Response to Submissions

Traffic and Parking

Hurlstone Agricultural High School (Hawkesbury)

20 August 2018

DRAWING  
Locality Plan

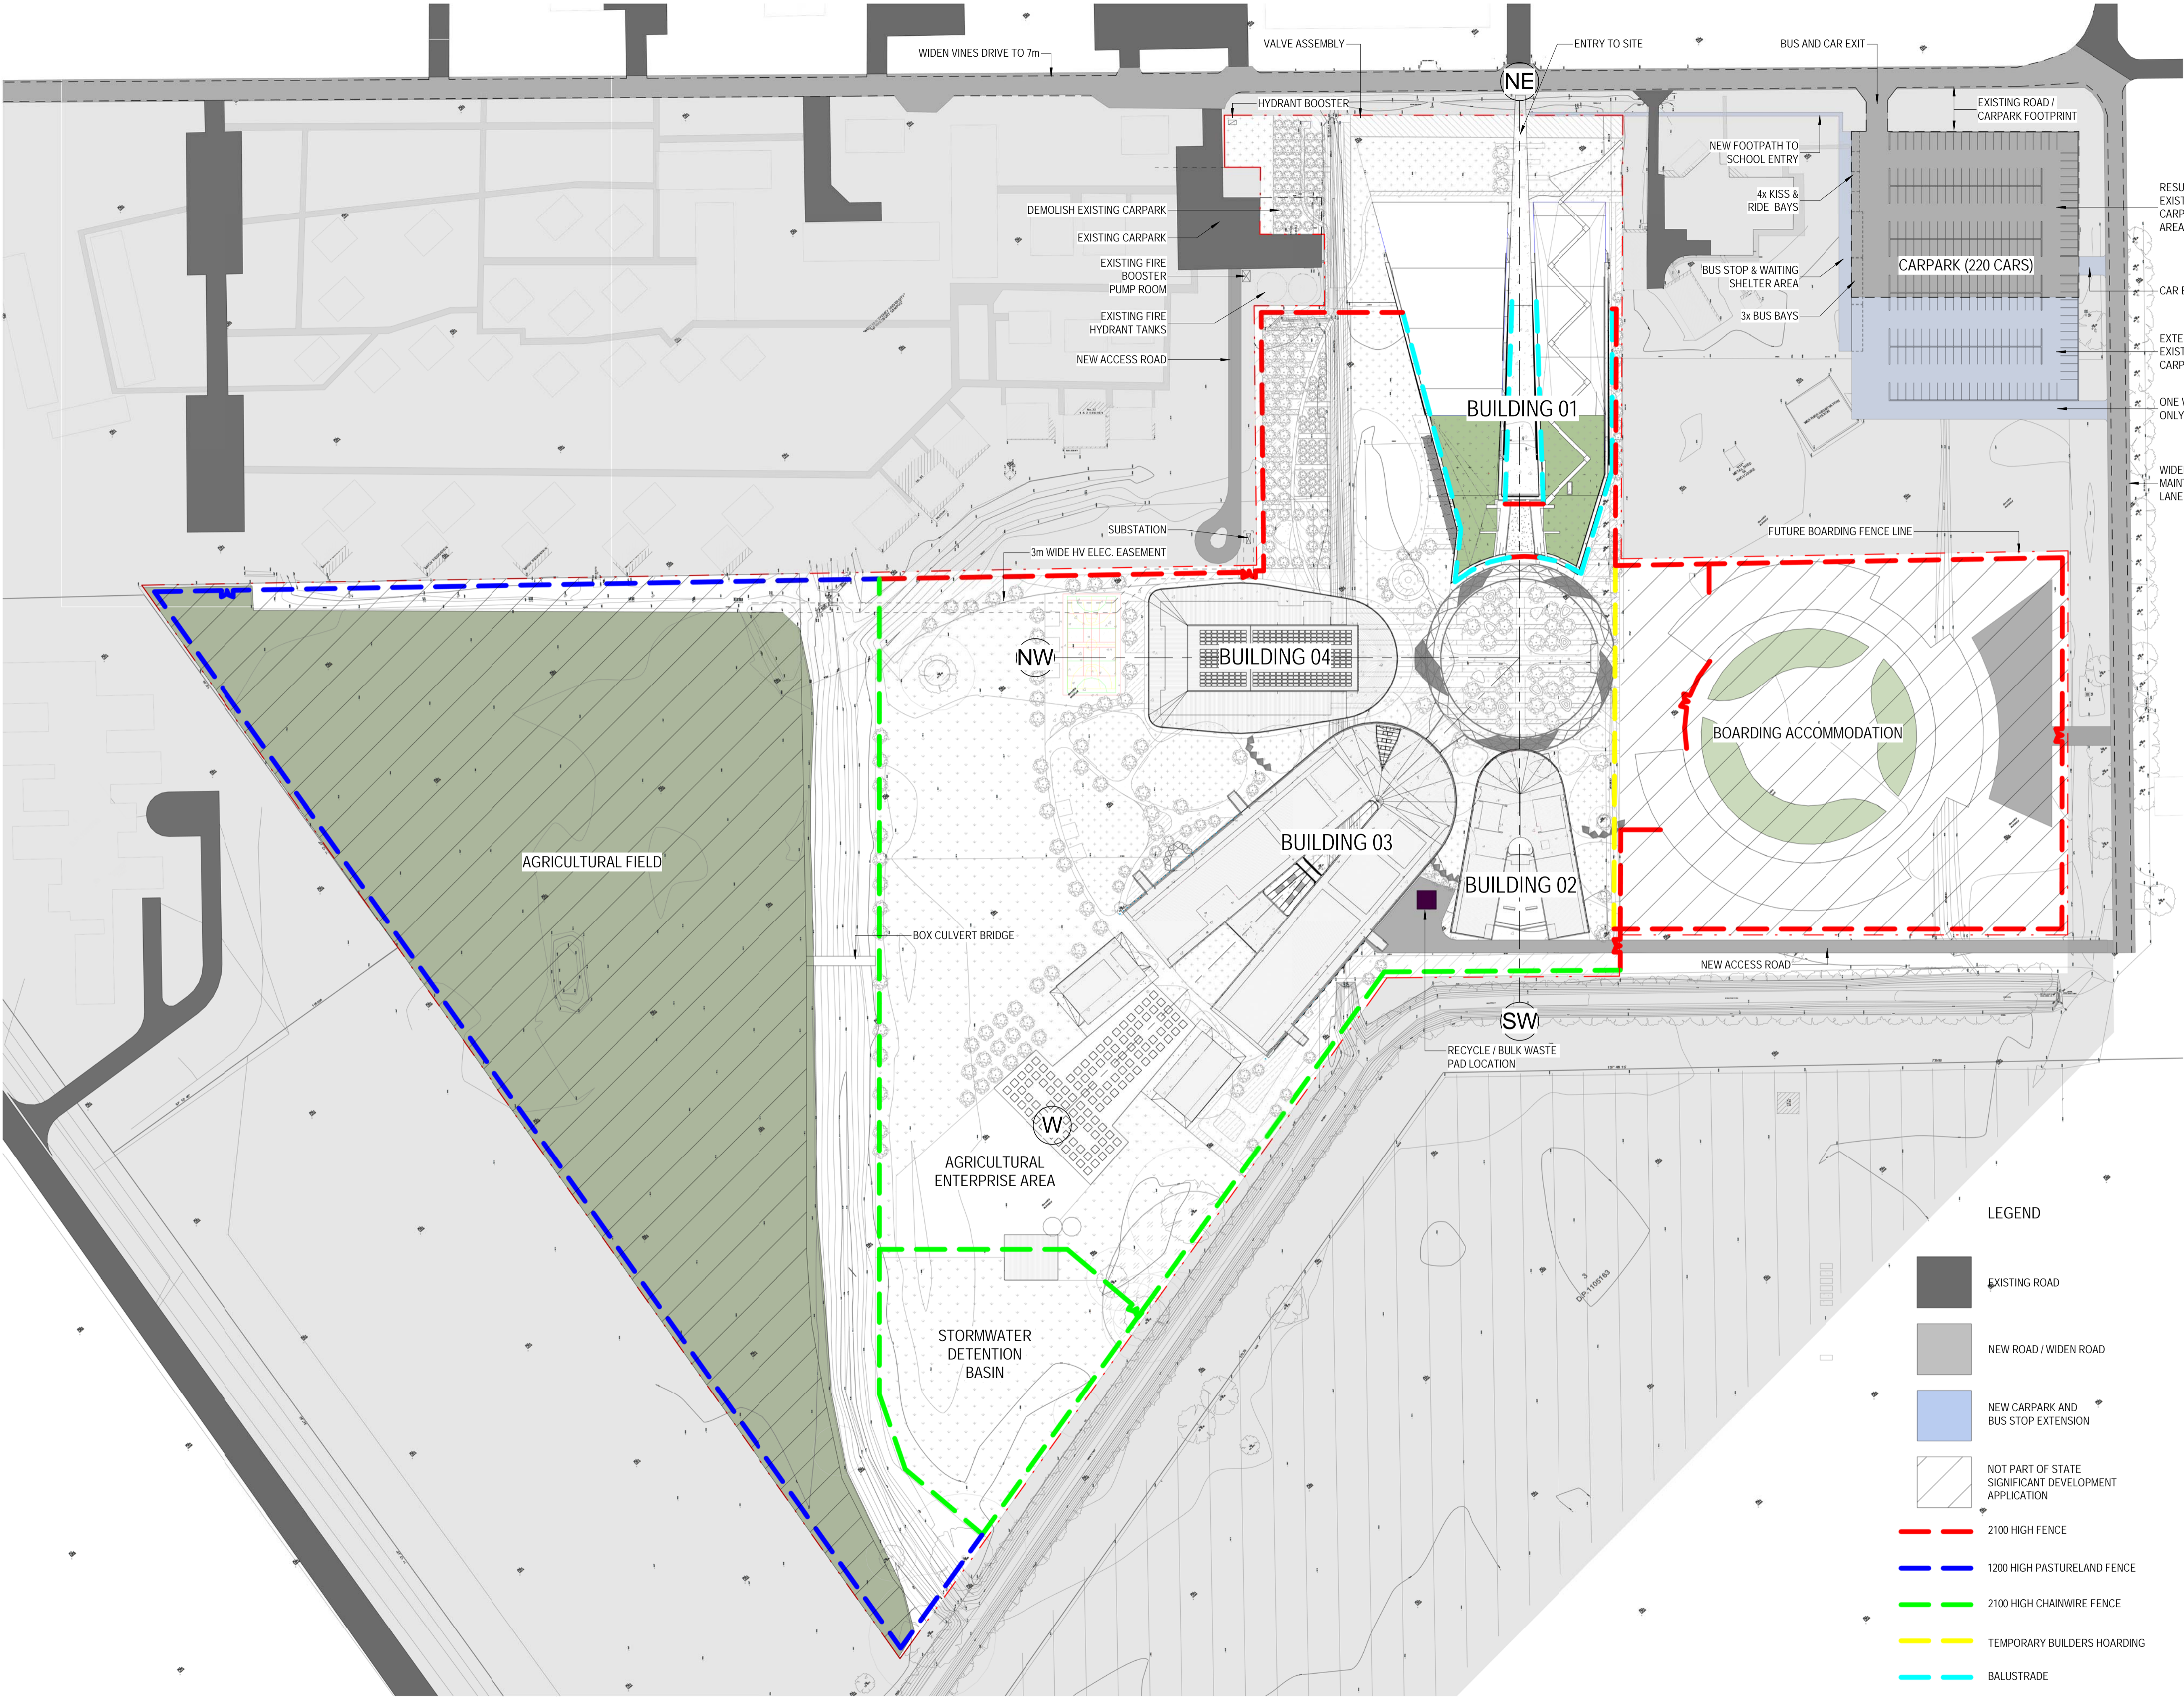
RMS has requested that the intersection of Londonderry Road and Vines Drive should be realigned so that it forms a cross intersection with Southee Road. Discussions with RMS indicate that insufficient information on road safety had been provided in the SSDA.

Council has requested that consideration be given to redirecting Vines Drive to line up with Southee Road and form a crossroad, and including an intersection treatment such as a roundabout.

The proposed design maintains the existing road alignment but provides widened edge radii to cater for safe bus movements.

Overall it is considered that there is not a need to modify the intersection layout (beyond widening to cater for the design vehicle), and a cross intersection may increase vehicle conflict and introduce additional traffic hazards by condensing vehicle movements. The current proposal, including additional changes to improve road safety, is deemed adequate for the desired purpose.

As discussed in Section 3.2, the current design proposal is to be maintained as there is considered insufficient need for a cross intersection layout. Council's submission specifically notes a roundabout as a possible intersection treatment. Some of the conflict issues as discussed in Section 3.2 could be improved by provision of a control method rather than an uncontrolled cross intersection. However, the need for such a modification remains insufficient, and the existing arrangement is considered suitable.

DRAWING  
Site Plan

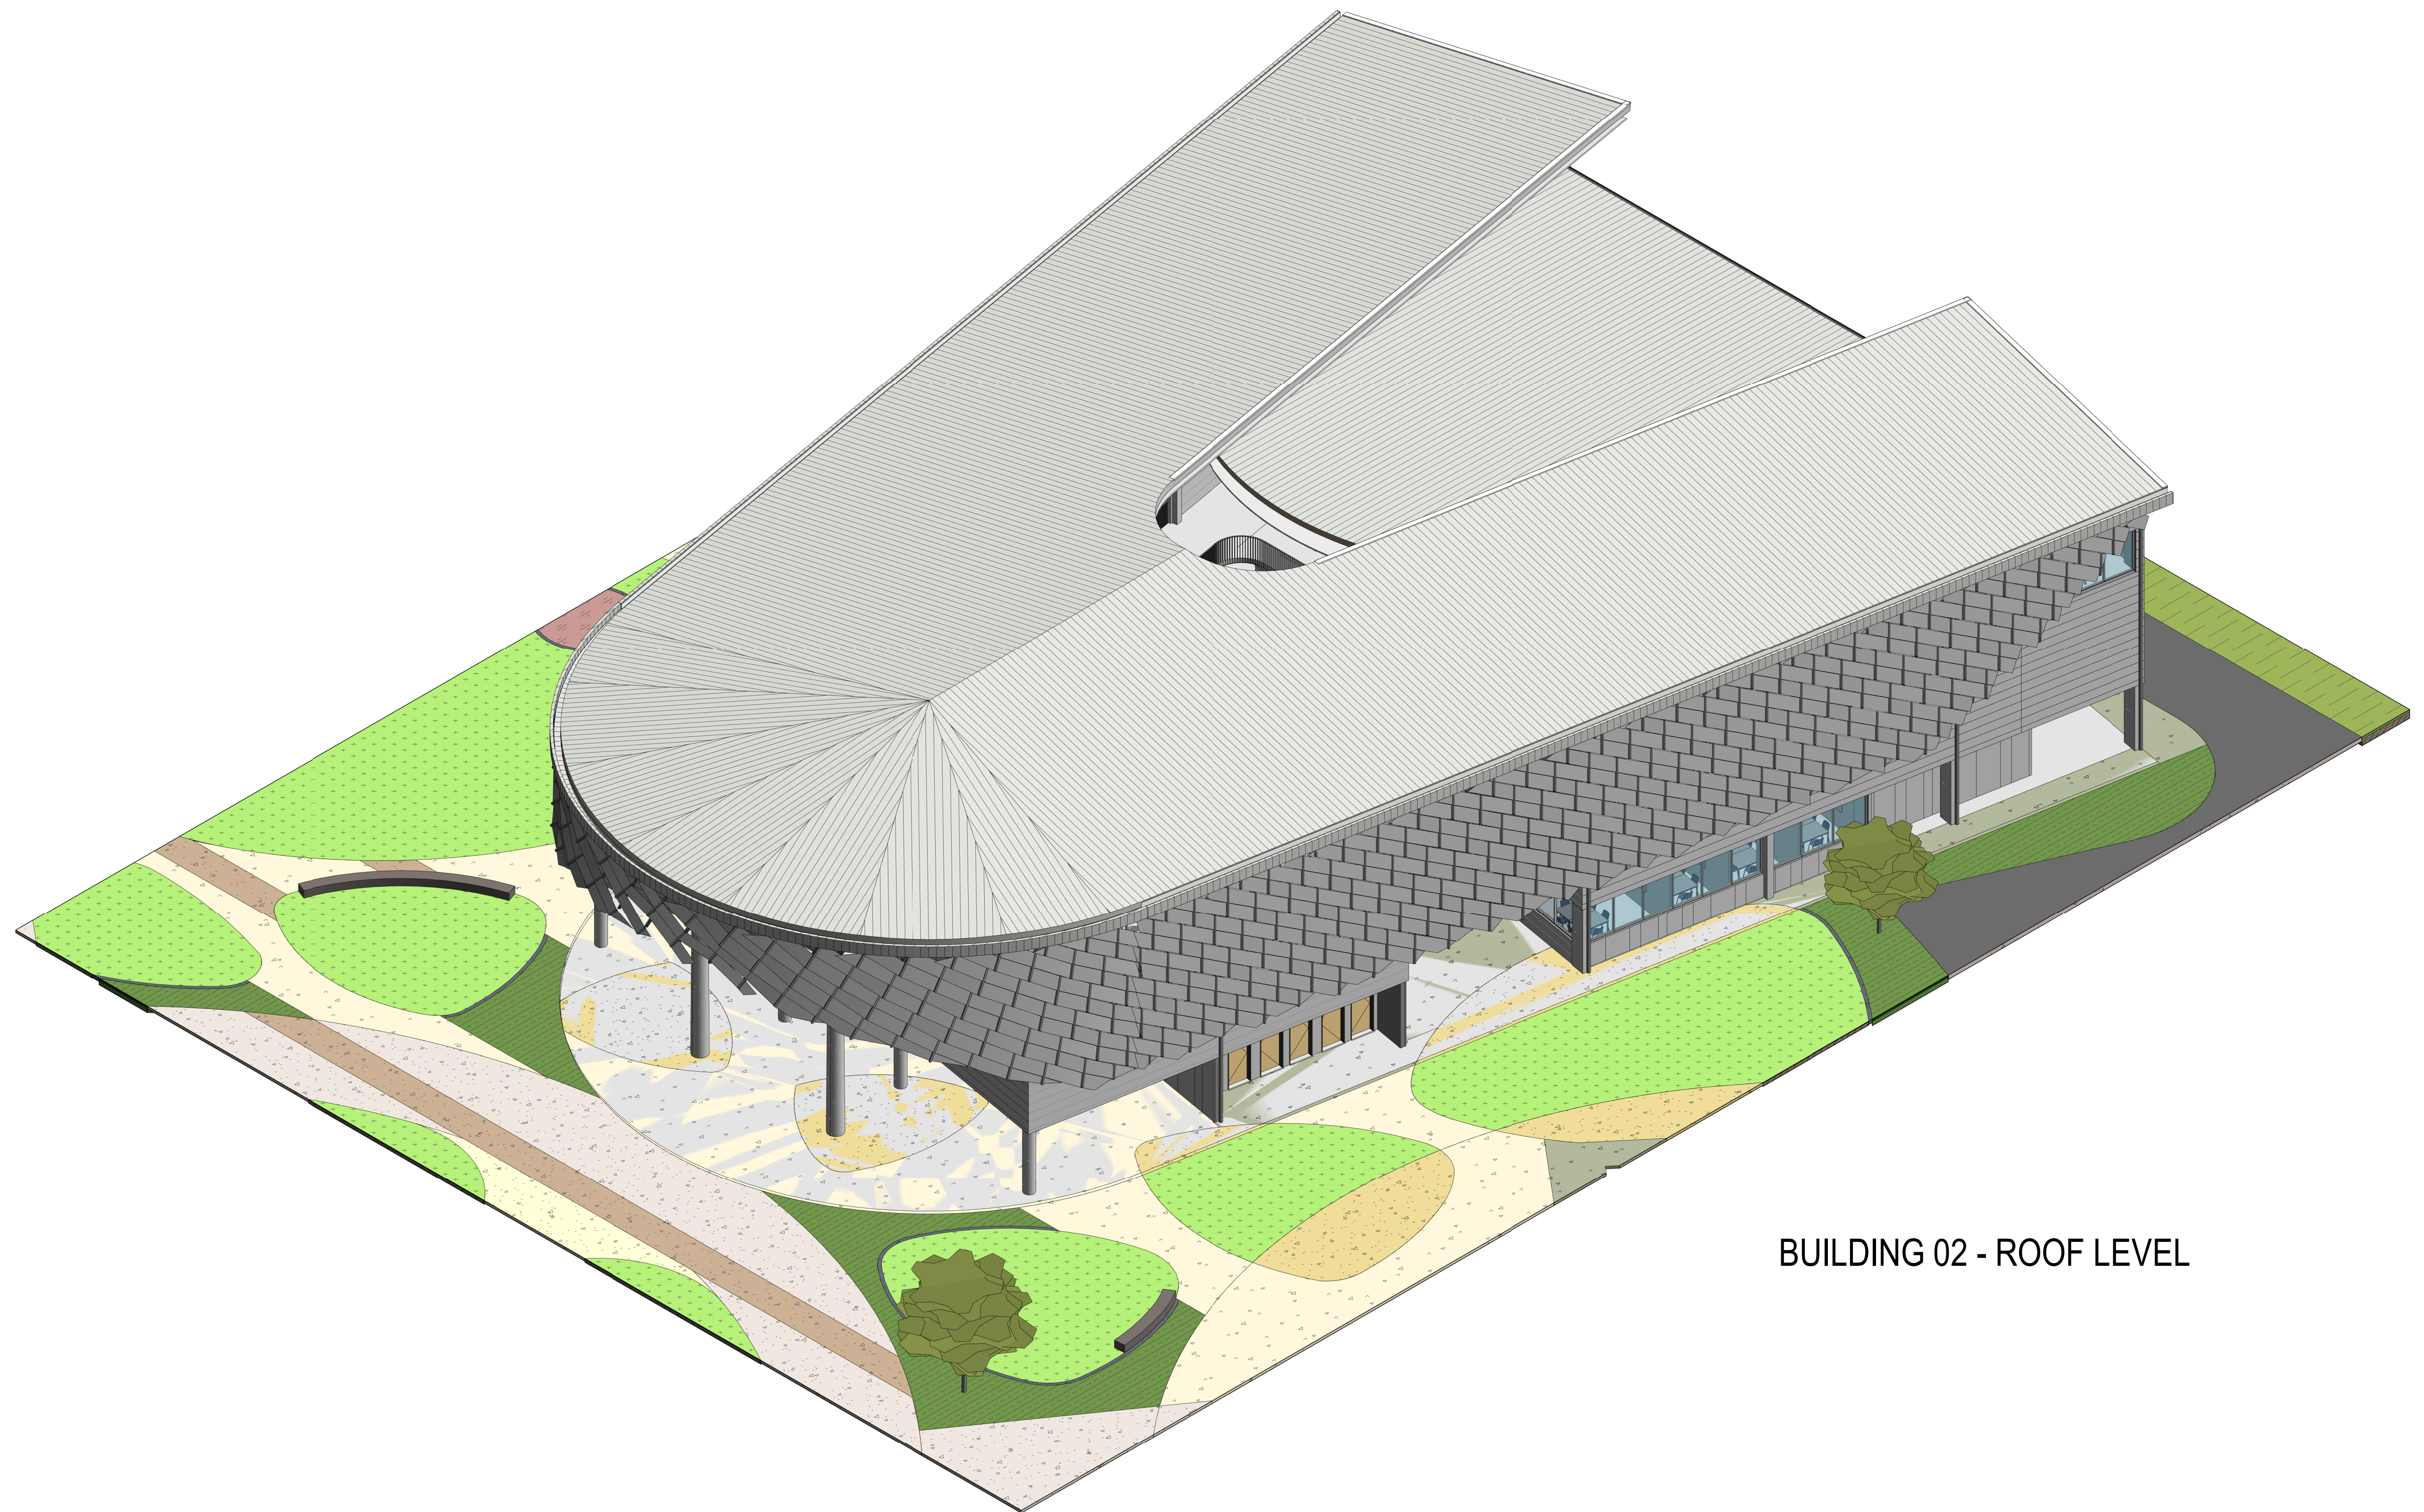
RMS has noted that the shared bus / car usage in the car park concept design is not ideal and requires physical separations. The detailed design has since been modified and provides a fully separated bus drop-off area including kerb separation, pedestrian fencing, pedestrian crossings, and modified access for improved safety.

TfNSW has noted that the car park concept design does not meet the drop-off / pick-up and bus capacities discussed in the Transport Assessment. The detailed design has since been modified to meet these capacities, with 5 bus bays and approximately 12 drop-off and pick-up spaces (73 metres) for cars. The design provides a fully separated bus drop-off area including kerb separation, pedestrian fencing, pedestrian crossings, and modified access for improved safety.
